Yarnton, Cherwell

Application Comments Response Note

162751A/N03

REV	DETAILS	DRAWN	CHECKED	DATE
STATUS:

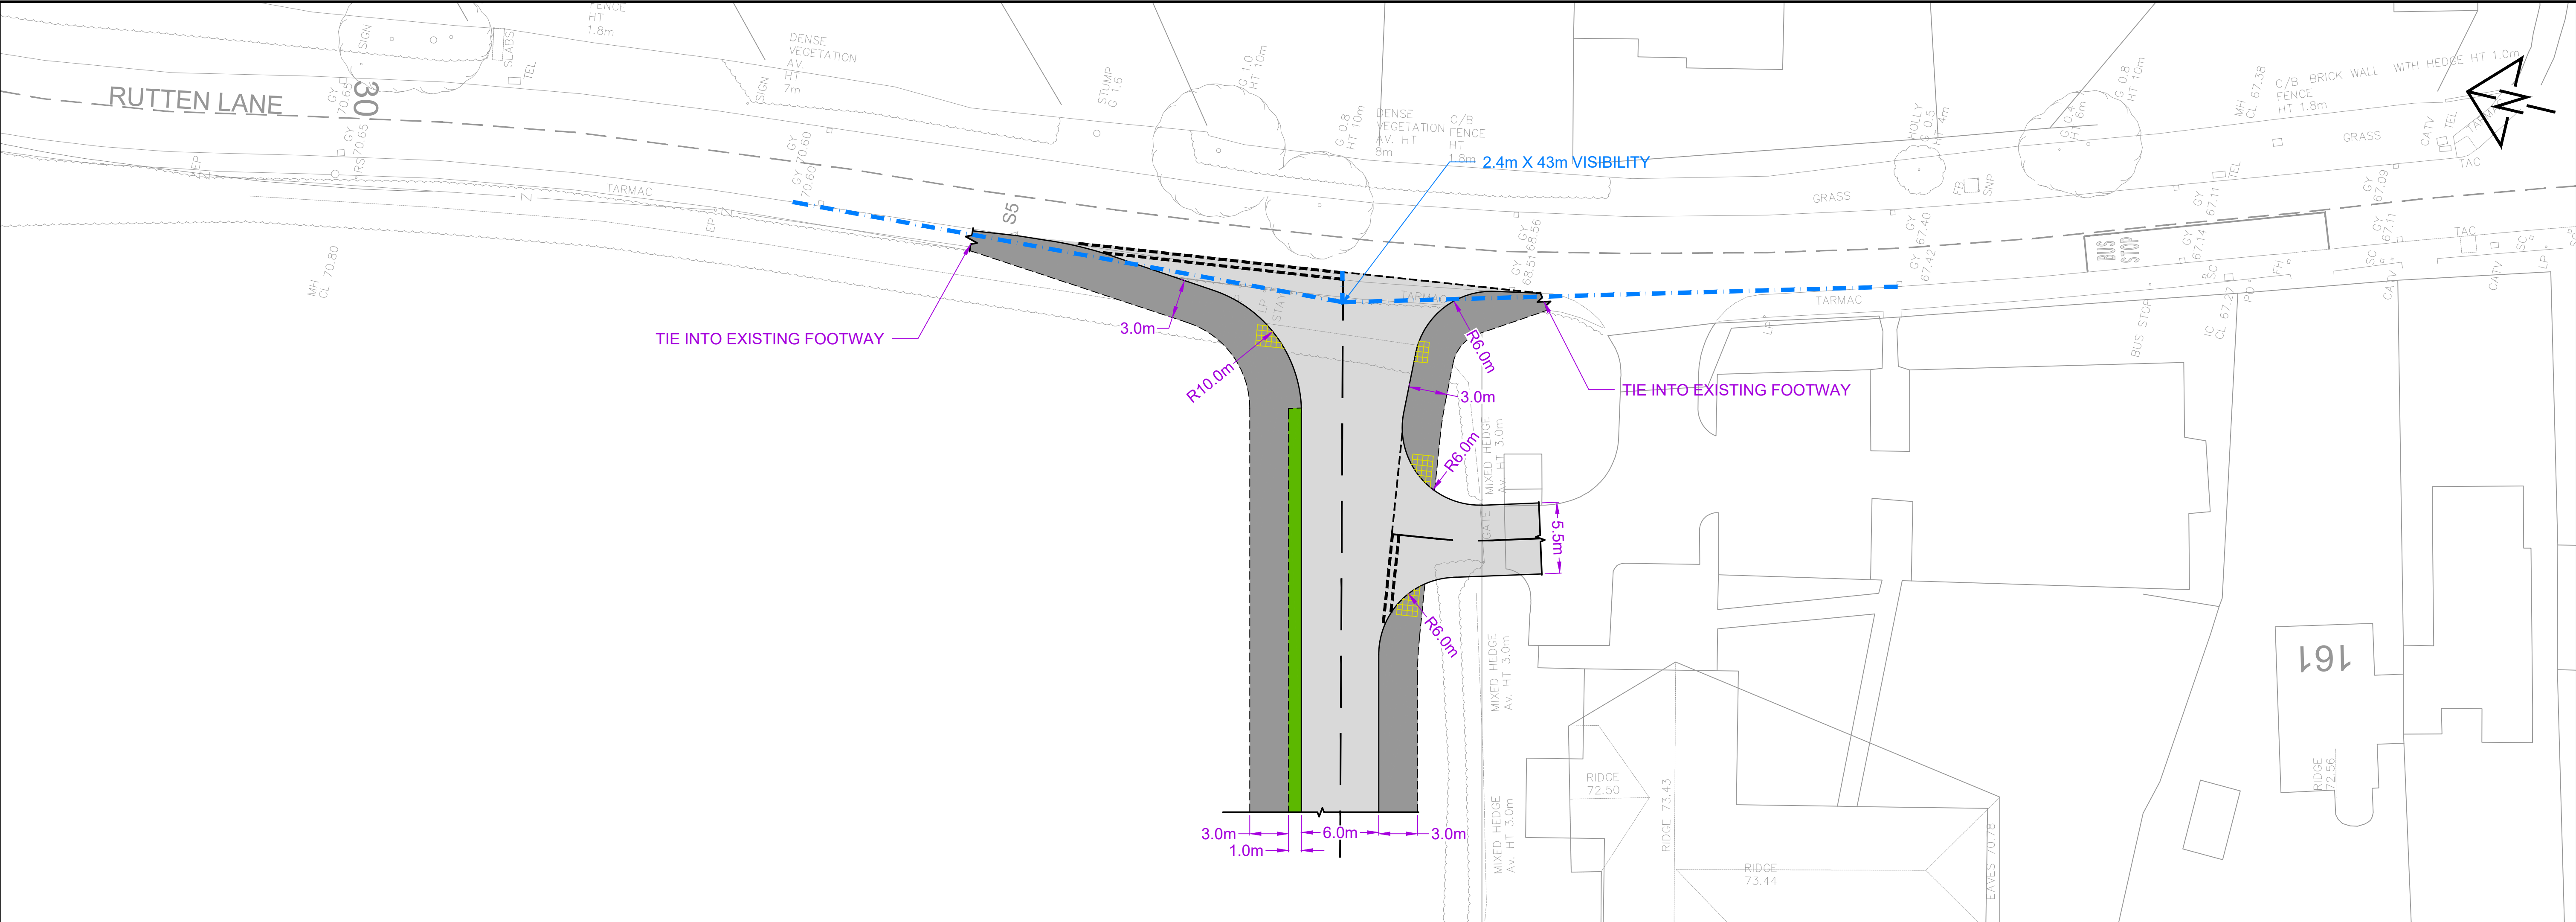
- Drawing 162751/B01/AT01 Rev D – tracking of the A44/ Begbroke Science Park access;
 - Drawing 162751A/PD02 Rev A – visibility splays in the vertical plane which show that the gradient of Rutten Lane is not a constraint to achieving suitable visibility, as contended by YPC;
